The Planning Officer
Arun District Council
Planning Department
Maltravers Road
Littlehampton
W. Sussex BN17 5LF

Proposed Alterations/Rebuild at 50 Ocean Drive, Ferring
Application No. FG/34/21/HH

1st FLOOR PLAN

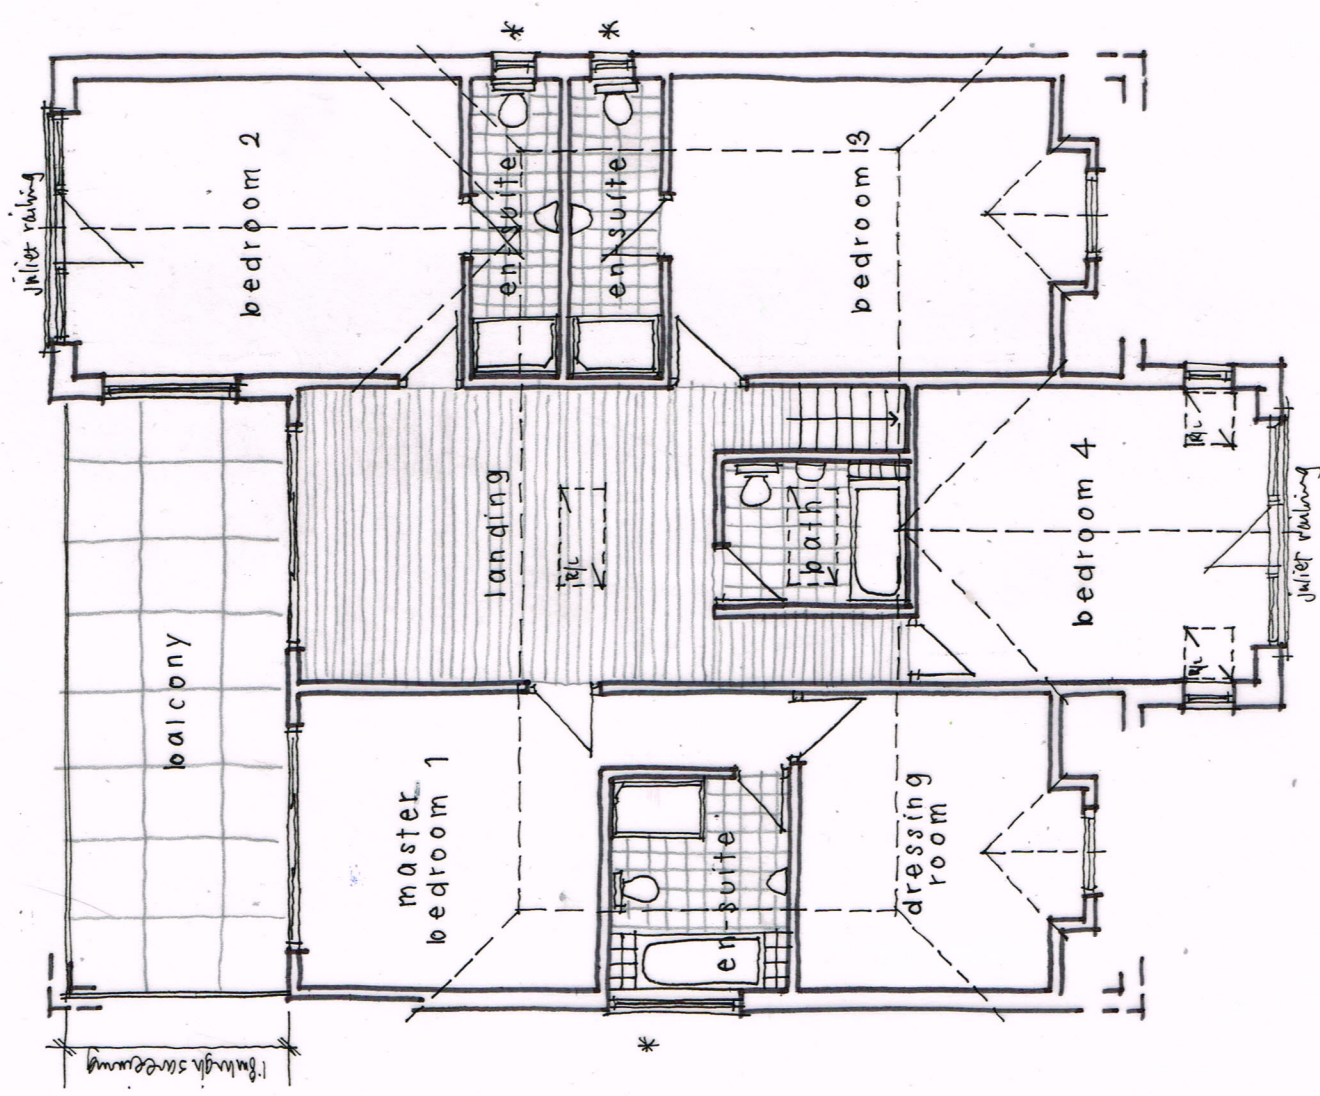
We would like to register our objections to this development. The property planned seems to be completely out of character with the rest of the area nearby. It will completely encompass the bungalows next door and what looks like first floor balconies will overlook every property in the vicinity including South Drive, depriving residents of these properties privacy in their houses and gardens.

Although there appears to be a "privacy screening" it seems to be to obscure the balconies from the side but will not prevent the occupants having a complete overview of all properties in the area.
